Our Ref: BR/231/19/PL

**Town & Country Planning Act 1990 (as amended)
Town and Country Planning (Development Management Procedure) (England) Order 2015
Application for Planning Permission**

Development Erection of first floor rear extension to provide 1 No. 2 bed flat (resubmission following BR/317/18/PL).

Location 86 Annandale Avenue Bognor Regis

EXISTING		PROPOSED	
ANANDALE DEVELOPMENTS		86 ANANDALE AVENUE	
BOOKING REQS		EXISTING ELEVATIONS	
DATE		SCALE	
08.08.2019		1:100	
A3		EX03

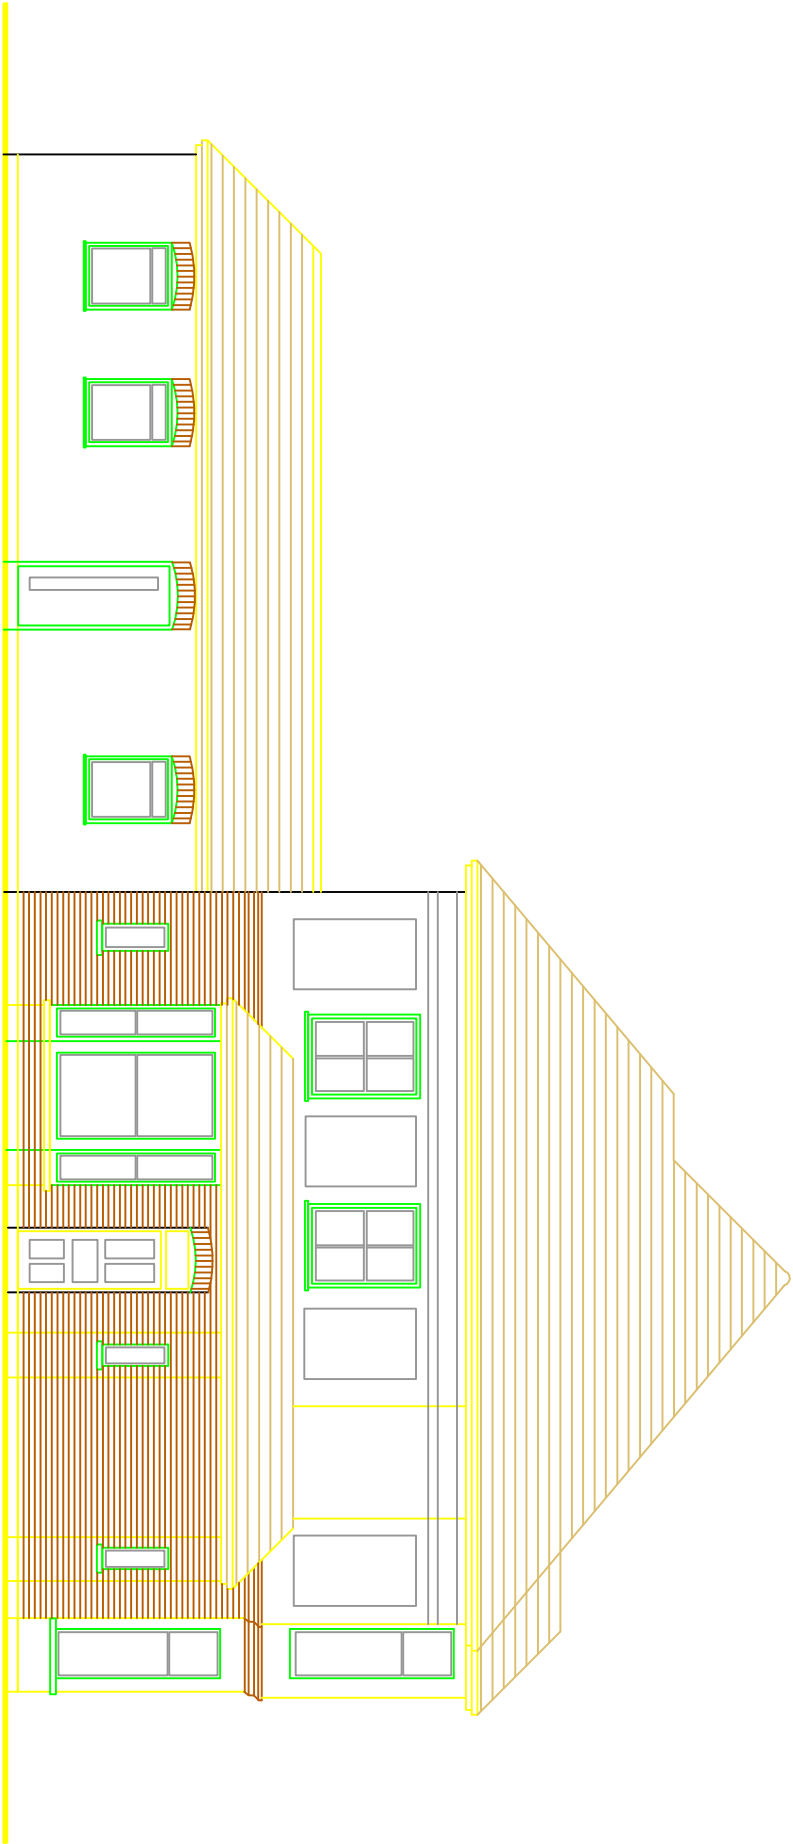
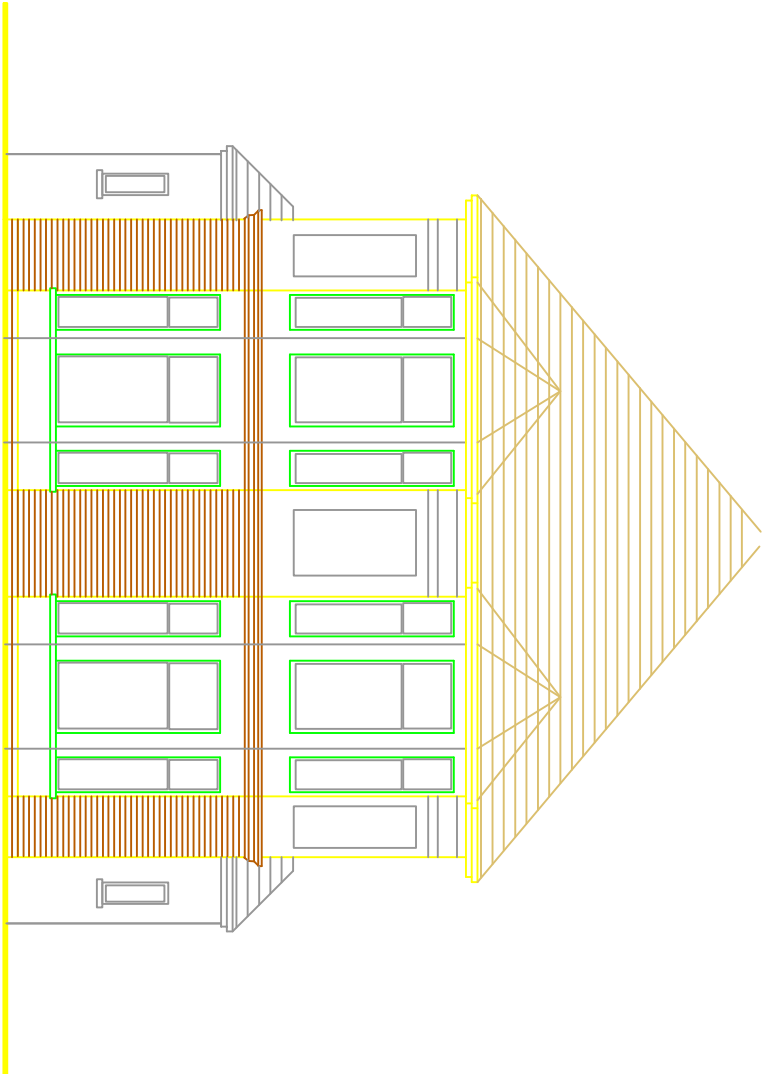
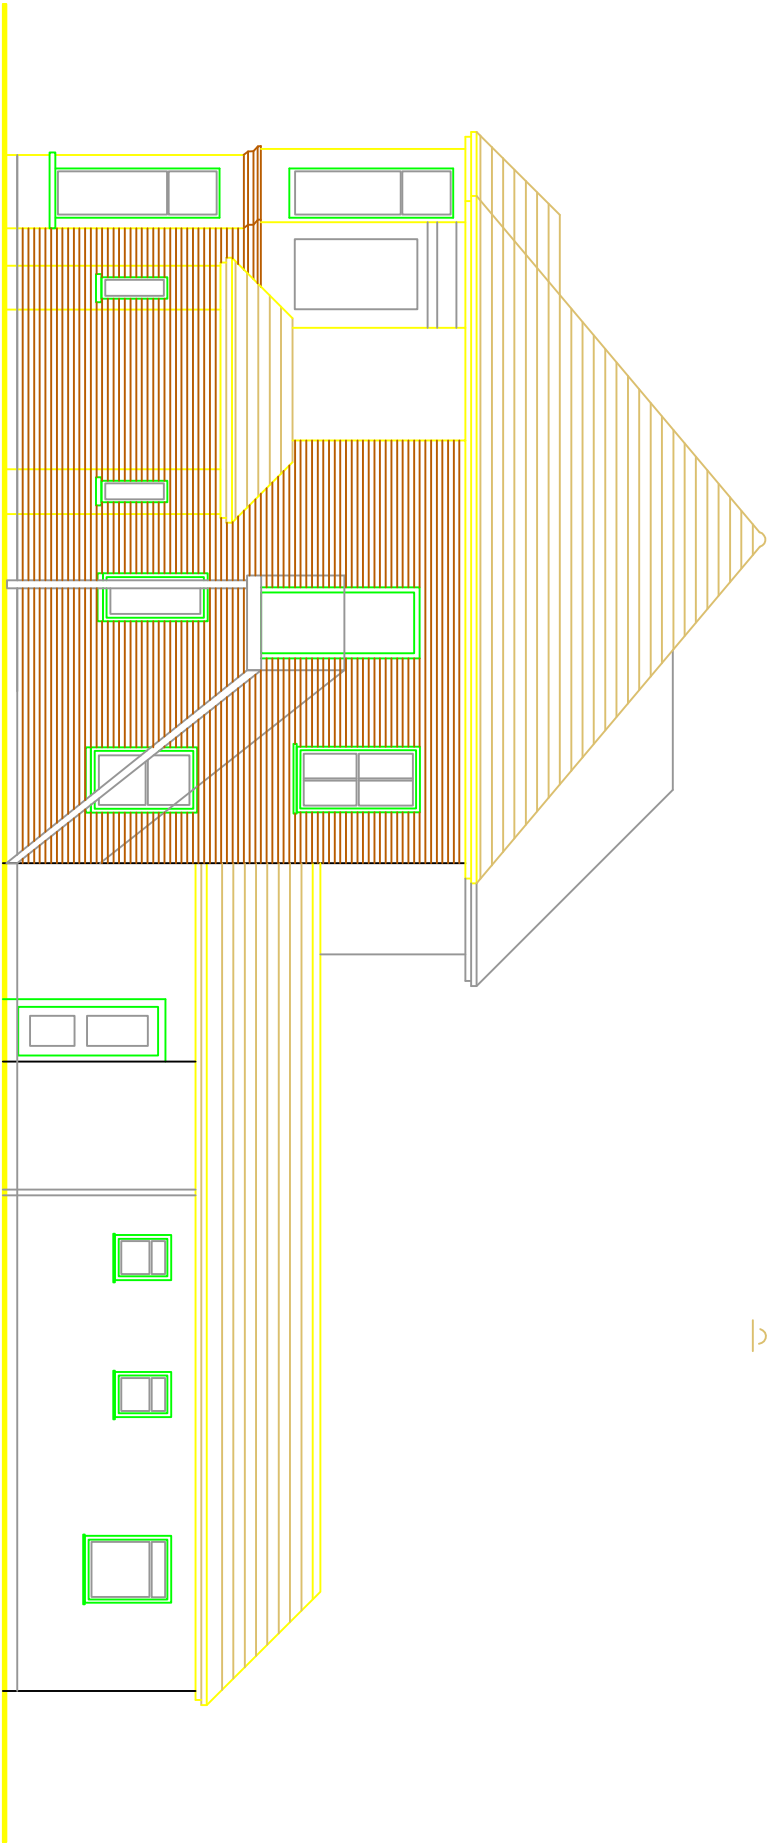
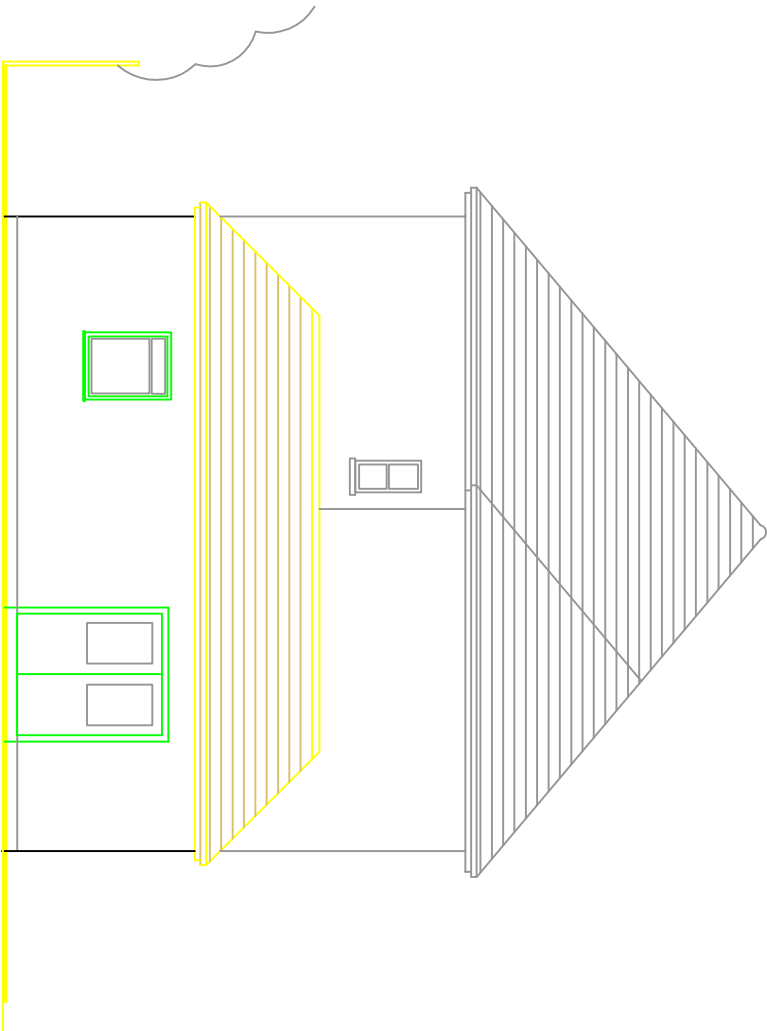
The existing ground floor plan and south west elevation do not accord. Please amend accordingly.

SITE		ADDRESS		TITLE		DATE		SCALE		SHEET NO.	
ANNANDALE DEVELOPMENTS		88 ANNANDALE AVENUE		PROPOSED ELEVATIONS		PLANNING		SJ		SJ	
		BOOKER REHS				08.08.2019		1:100		6

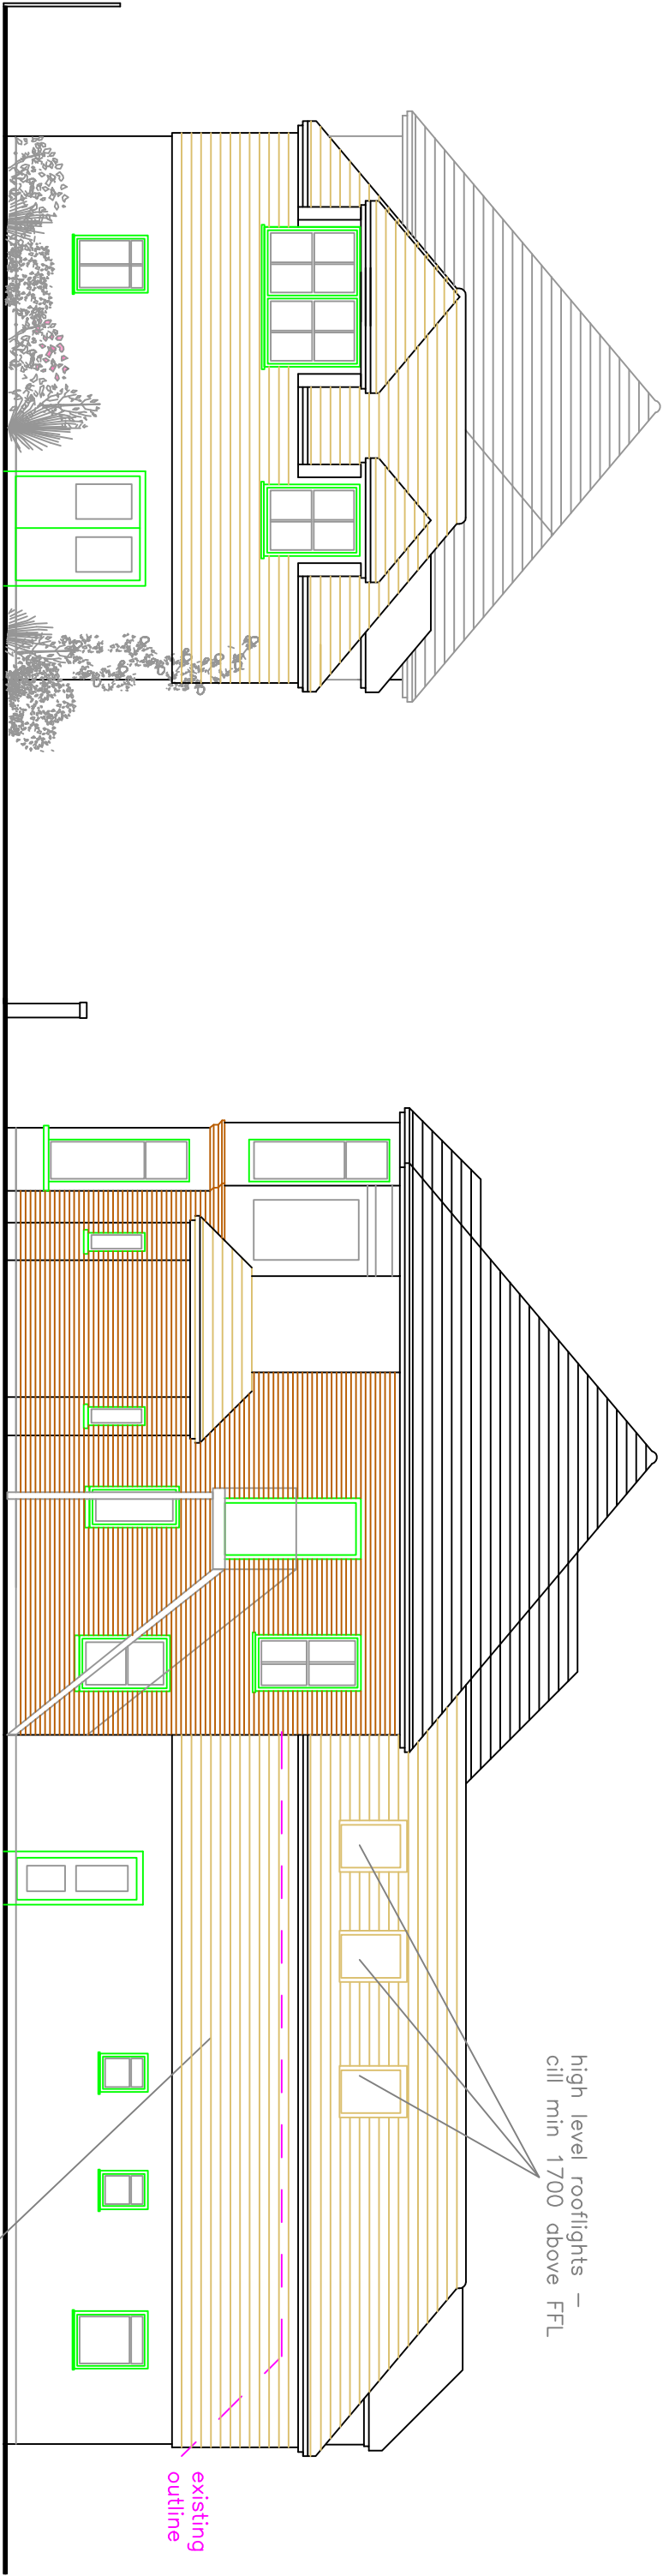
The proposed ground floor plan and south elevation do not accord. Please amend accordingly.
